KITITAS COUNTY

TO: All Staff
FROM: Justin Turnbull, County Surveyor 
DATE: December 18, 2020
SUBJECT: County Survey Review of BL-20-000224 Flowers

UNIFIED SITE PLAN
FOR
TAX PARCEL NUMBERS 832534 AND 221136
FOR
BEN & LINDSEY FLOWERS

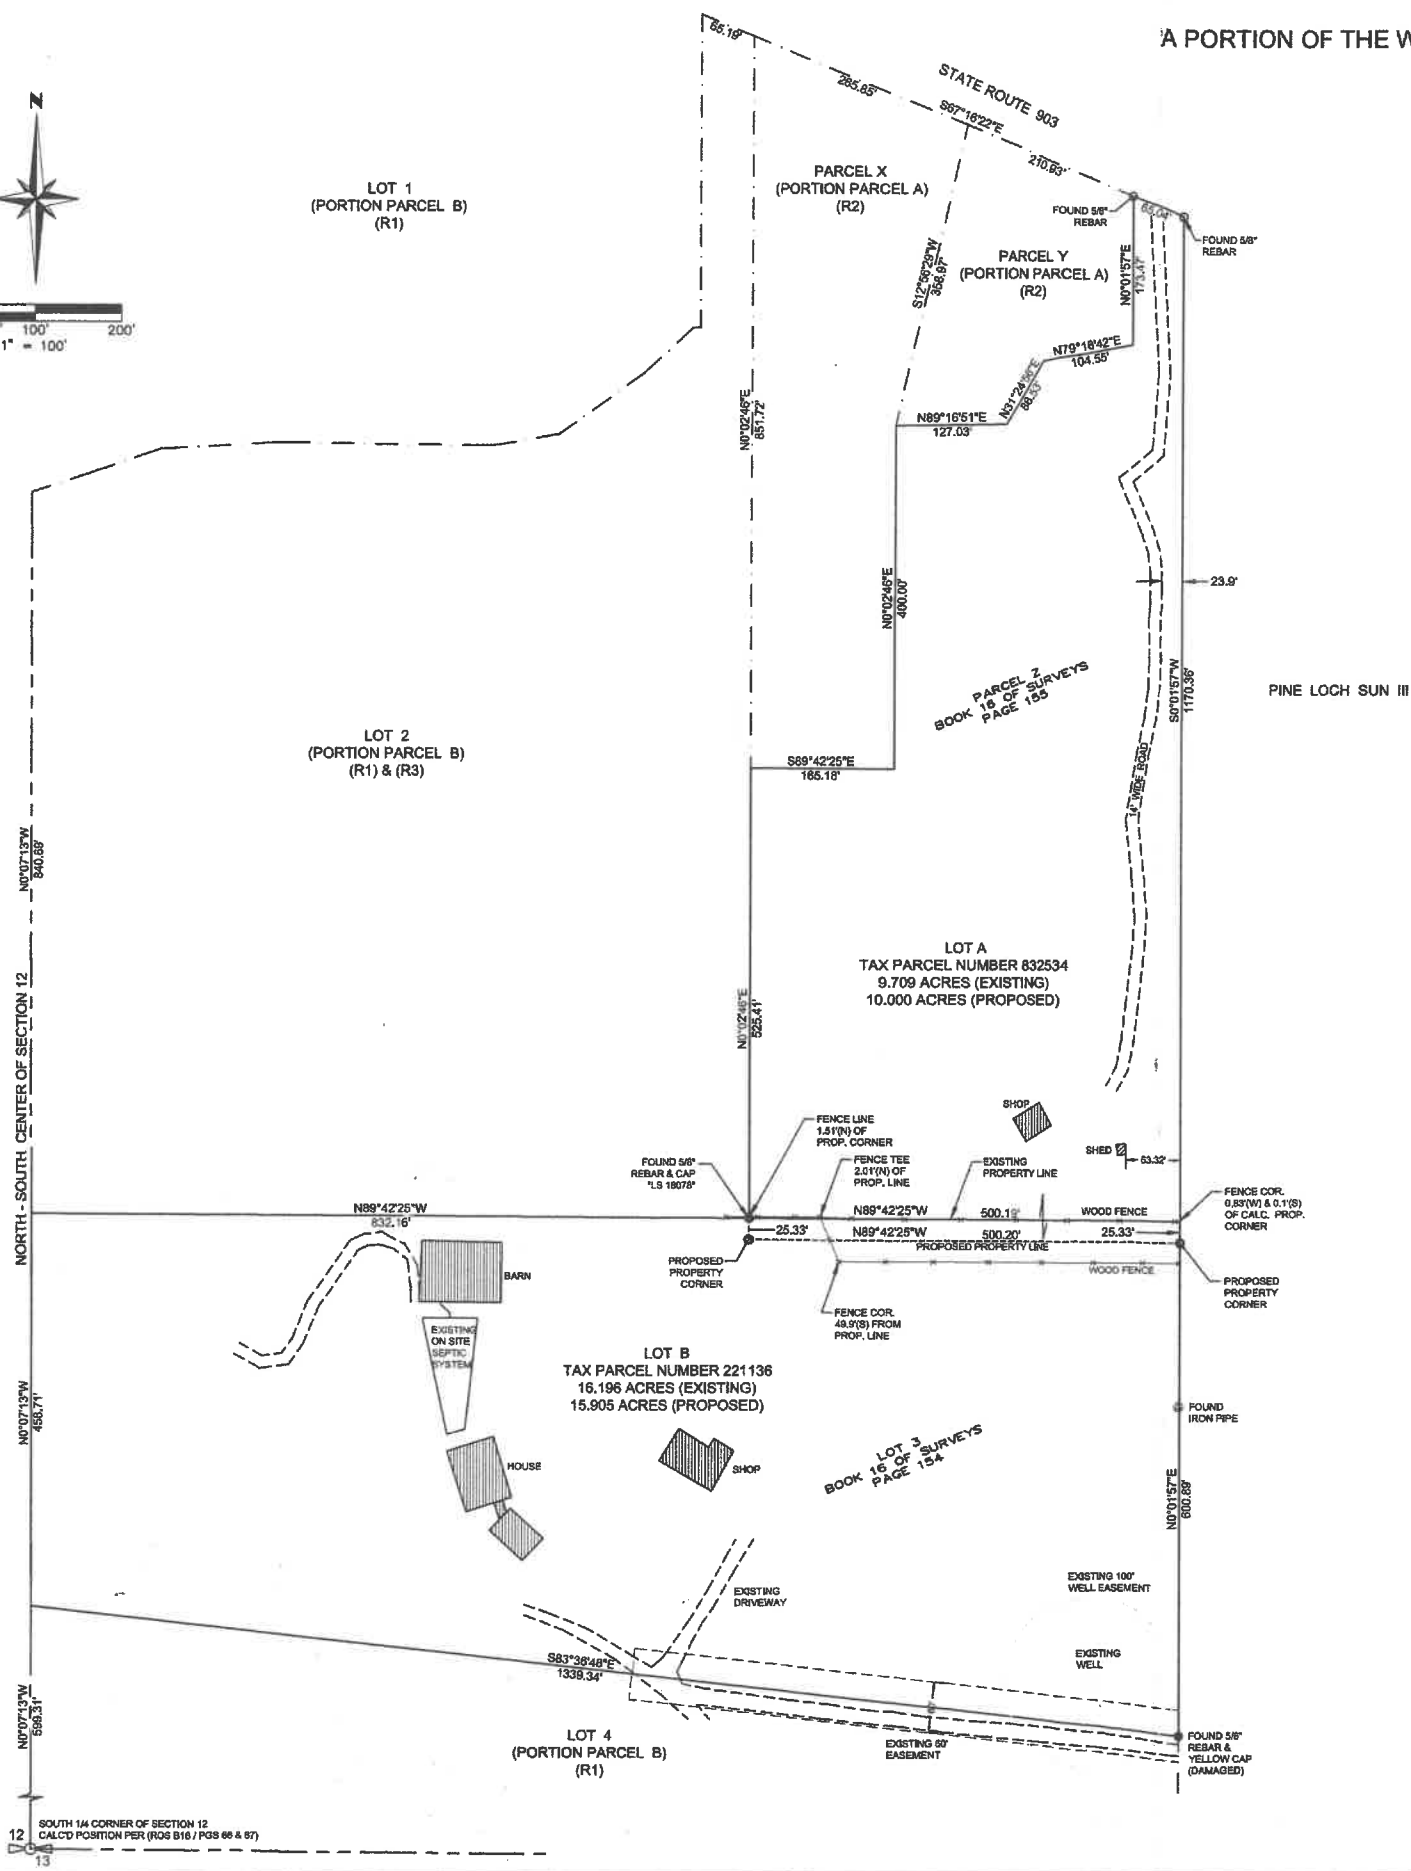
1. Sheet 1 is missing the legend.
